LIME DOWN SOLAR PROJECT

**DEADLINE 6 SUBMISSIONS
STOP LIME DOWN**

August 2026

Drawing file: published-documents / EN010168-002330-6.2 ES Volume 2 Figure 11-7 Lime Down E2 Fluvial and Surface Water Flood Map (Rev 3).pdf

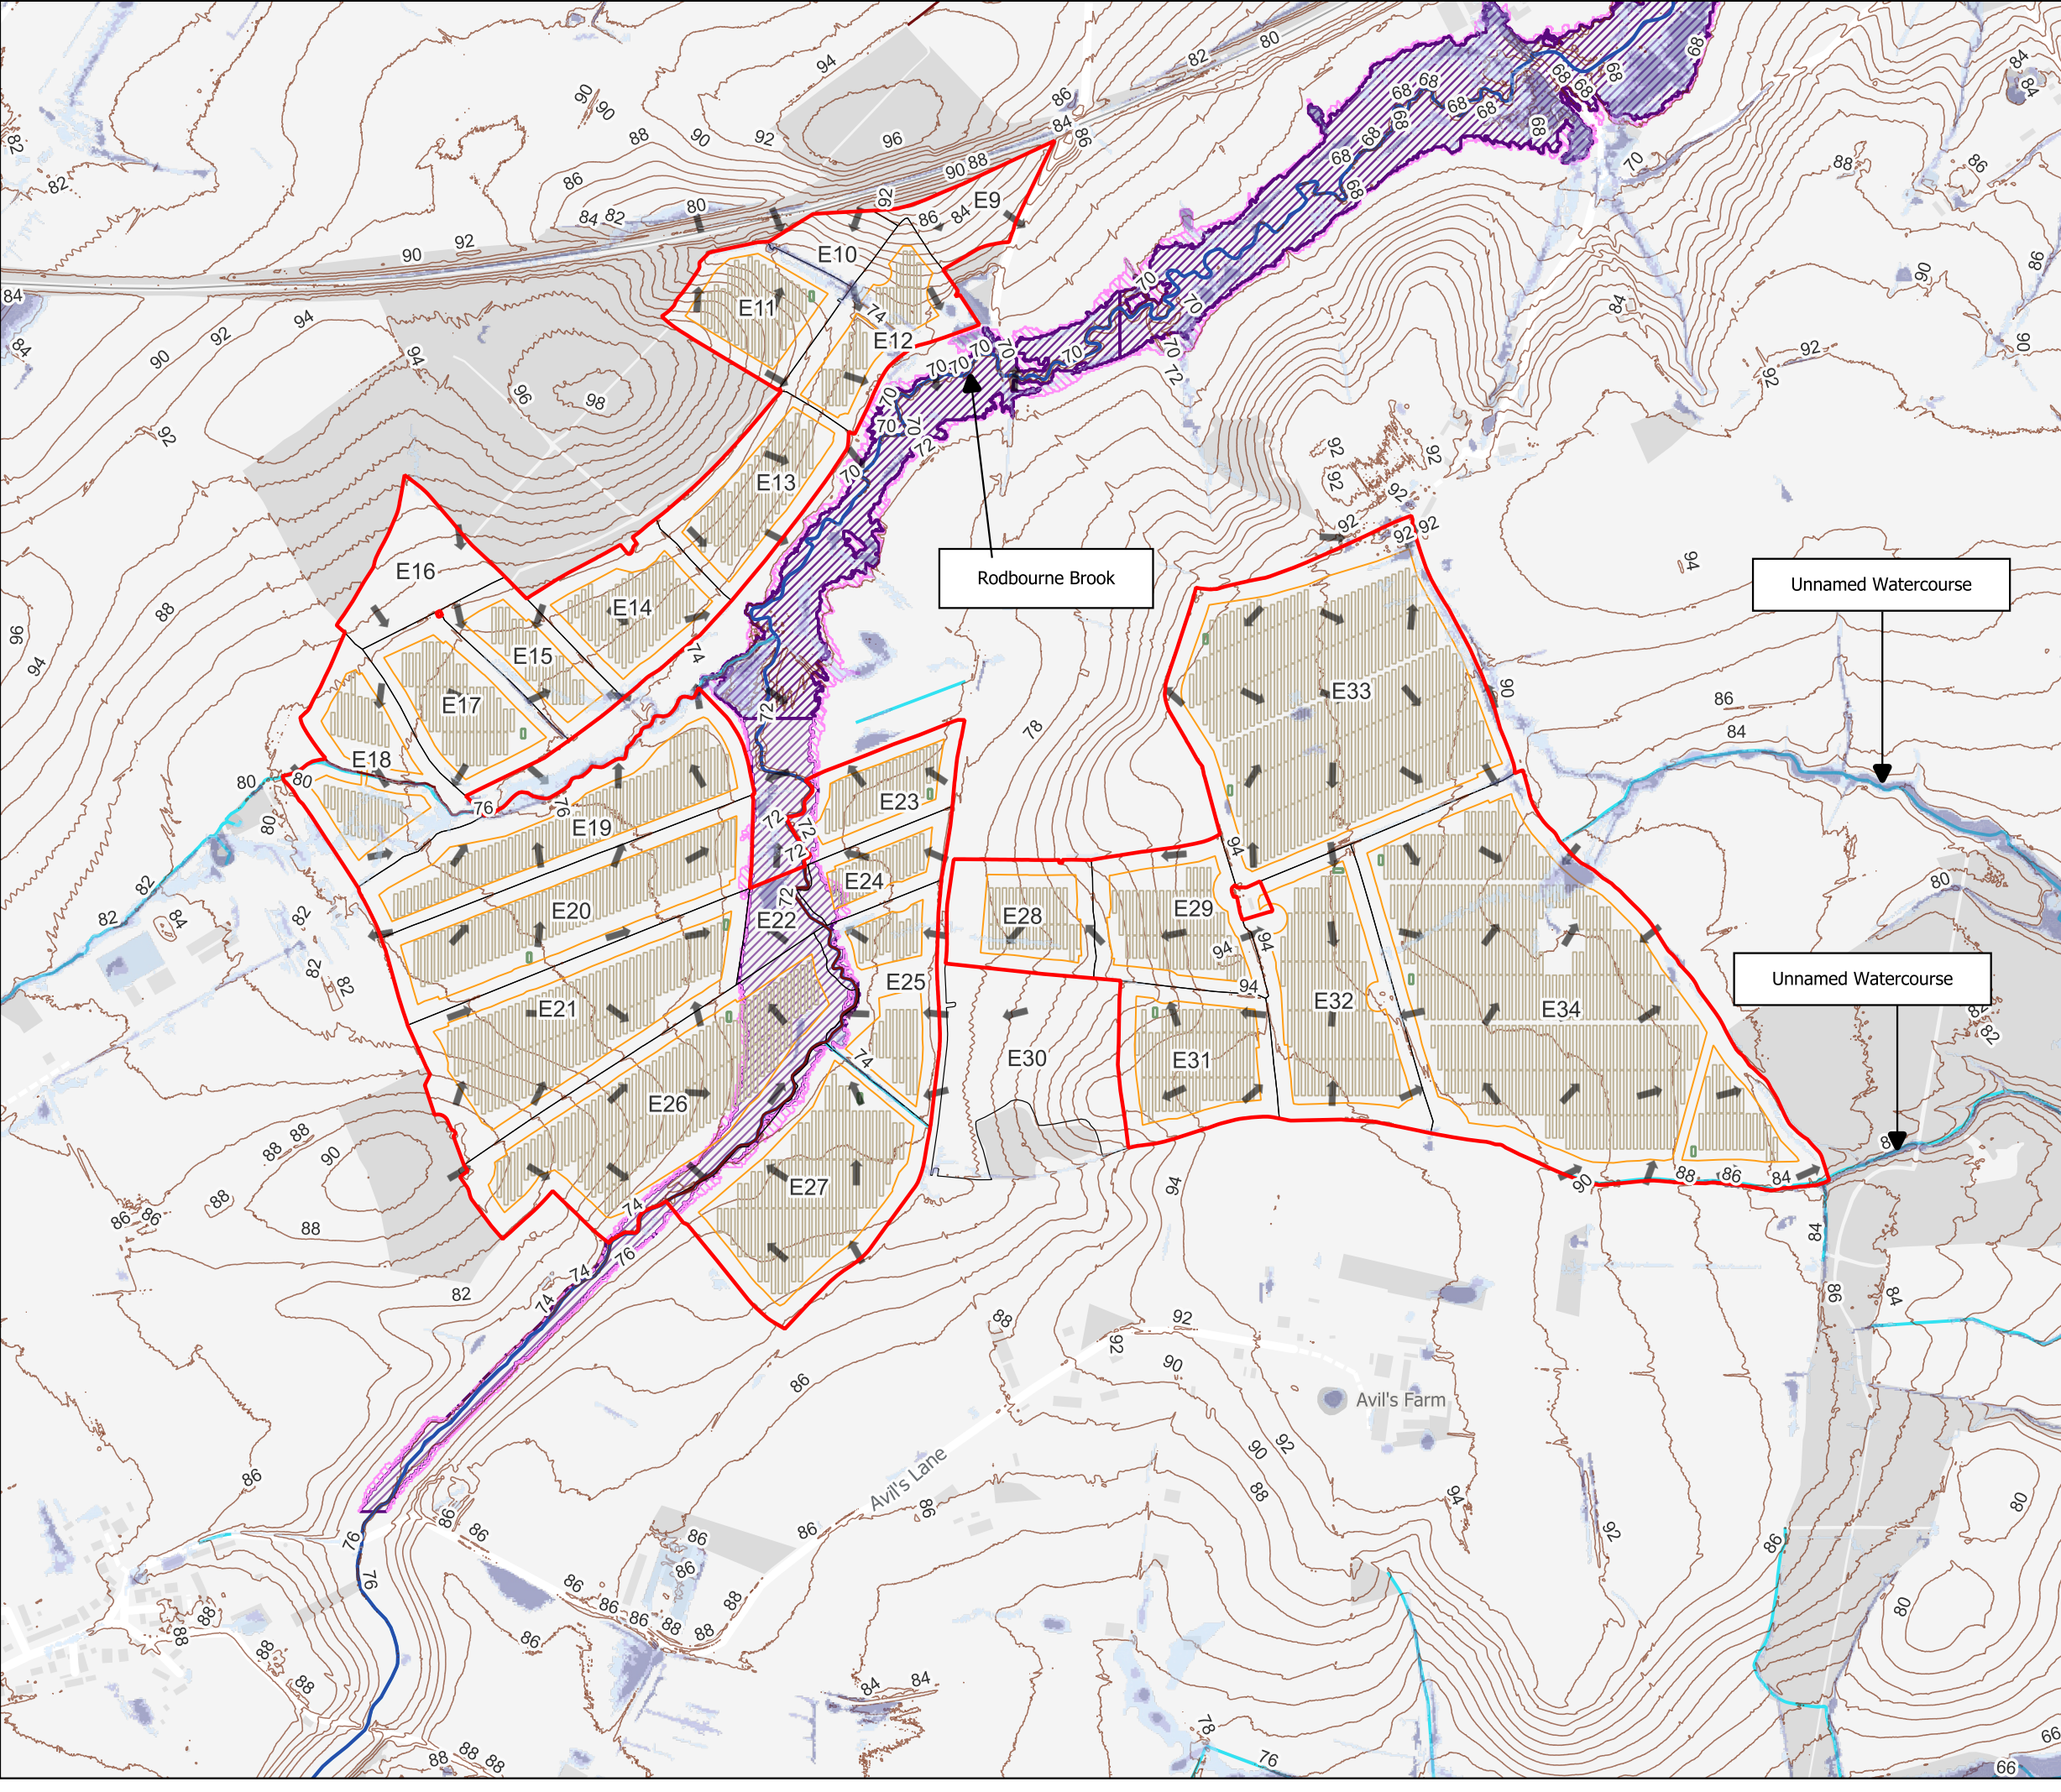
2.3.1. The flood maps have been updated by adding in what appears to be a scale plan of the solar panel rows. The flood risk maps incorporate EA maps showing both surface water flooding and fluvial flooding. The latter is only calculated where the catchment areas are large enough – in other parts of the site, surface water flooding has to stand proxy for fluvial flood risk. On the Area C1 map [REP5-032], the surface water flooding extent has been completely omitted from the panel areas. There are also omissions in parts of the Area A map [REP5-030]. These omissions give a misleading impression of surface water flood risk and should be corrected.

2.3.2. Additions to the maps requested by the ExA have provided some valuable insights into how well the solar panel areas are connected to the drainage network, both in the form of dug ditches (though not all of these are shown) and flow paths which show up as connected areas on the Risk of Flooding from Surface Water (RoFSW) maps incorporated in the Flood Map for Planning, which form connected pathways at times of high flow:

- Ditches intercept overland flow routes from the panels in many places (e.g. Fields A9, B6, B7, B11, C7, C34, C14, C15, D1, D2, D3, D4, D5, D6, D7, D8, D11, D19, D20, D21, D22, D23, D24, E2, E3, E11, E17, E20, E21, E24, E31, E32, E33, E34);
- Fields containing RoSWF areas include A2, A6, A7, C7, C14, C19, C21, C22, E4, E12, E33 and E34;
- Fields close to RoSWF channels include A2, A6, A7, A9, A10, C7, C19, C21, C22, E2, E3, E4, E14, E15, E17, E18, E19, E33 and E34;
- Fields close to ordinary watercourses or main rivers include A10, B10, C22, D8, D11, D12, D13, D14, D16, E4, E12, E13, E14, E19, E20, E21, E23, E24, E25, E26, E27 and E34;
- Panels are located in areas at risk of fluvial flooding in Flood Zones 2 or 3 in Fields D12, D13, D14, D17, E22, E24 and E26;

2.3.3. The maps thus show that most of the panel areas are well-connected to the existing drainage network, which implies that the areas with enhanced runoff as demonstrated in [REP5-130] Appendix D are likely to transmit the excess water to the river system reasonably quickly. The drainage ditches and overland flowpaths flow into the ephemeral stream network and from there into the four permanent streams that drain into the Avon – the Rodbourne Brook, Gauze Brook, Norton Brook and the un-named stream entering the Avon upstream of Whatley Manor. The fluvial and surface water flood maps thus provide evidence that flood risk is likely to increase off site due to the Scheme, though they do not allow it to be quantified.
